Online Comment

Application H16-0682-26
Location The Hollies Farmyard Pilmore Lane Fulney PE12 6EG
Proposal Erection of 4 no. dwellings, change of use of existing packhouse to a single dwelling and demolition of agricultural buildings.

Name Diane Gordon
Address SHDC Environmental Protection

Demolition Site Plan

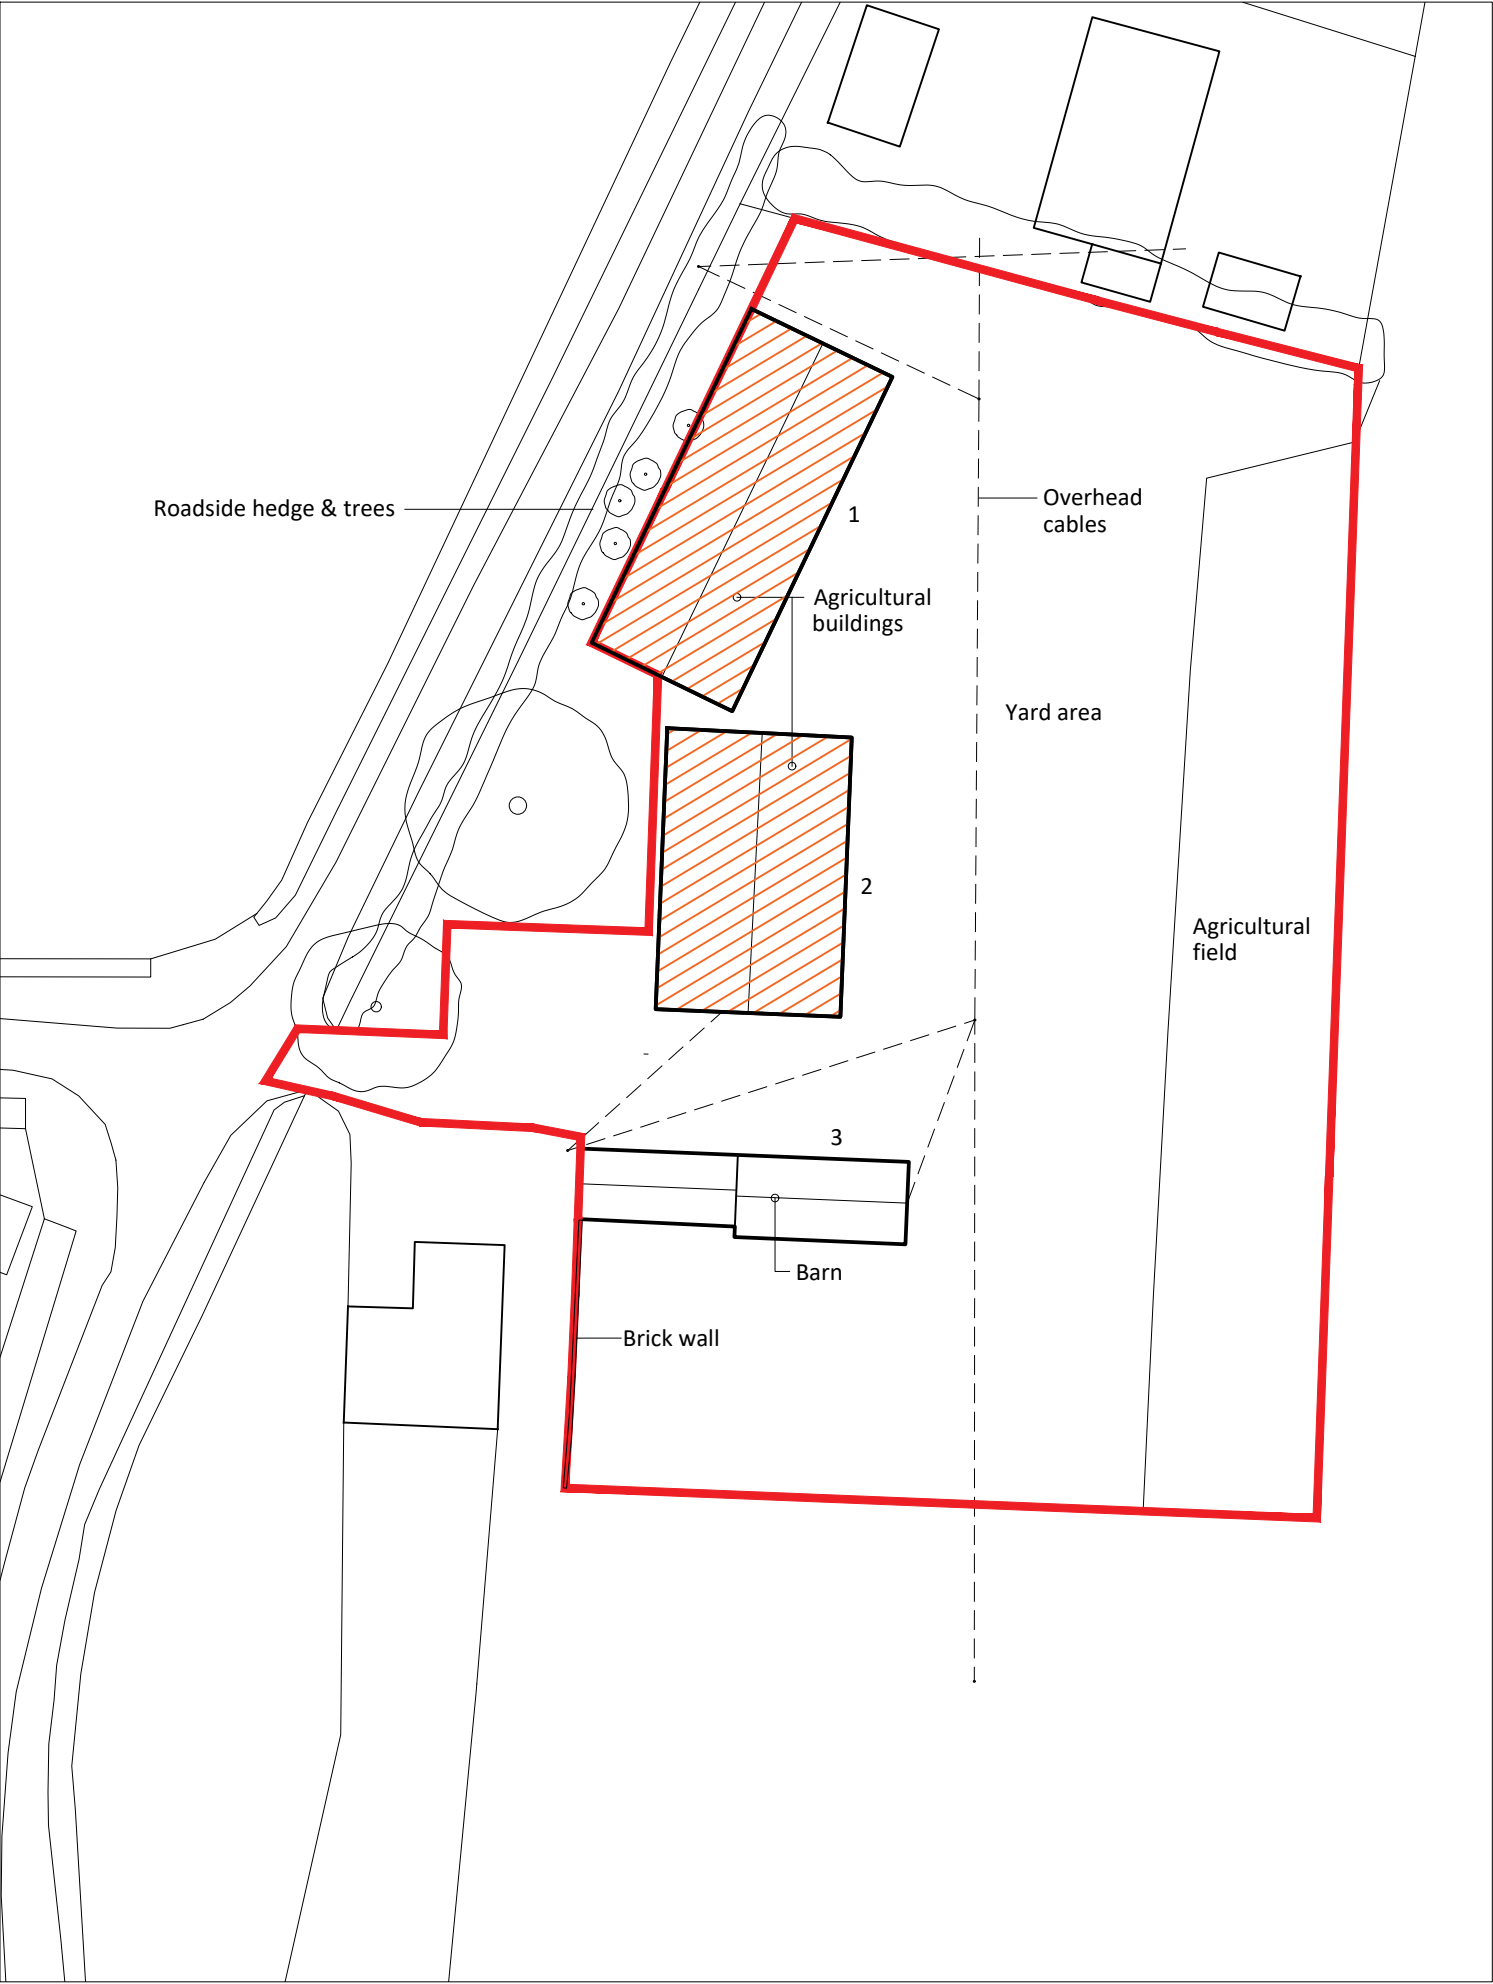
a Construction Environmental Protection Management plan should be provided detailing working hours and dust management. this should make reference to the IAQM guidance on assessment of dust from demolition and construction jan 2024
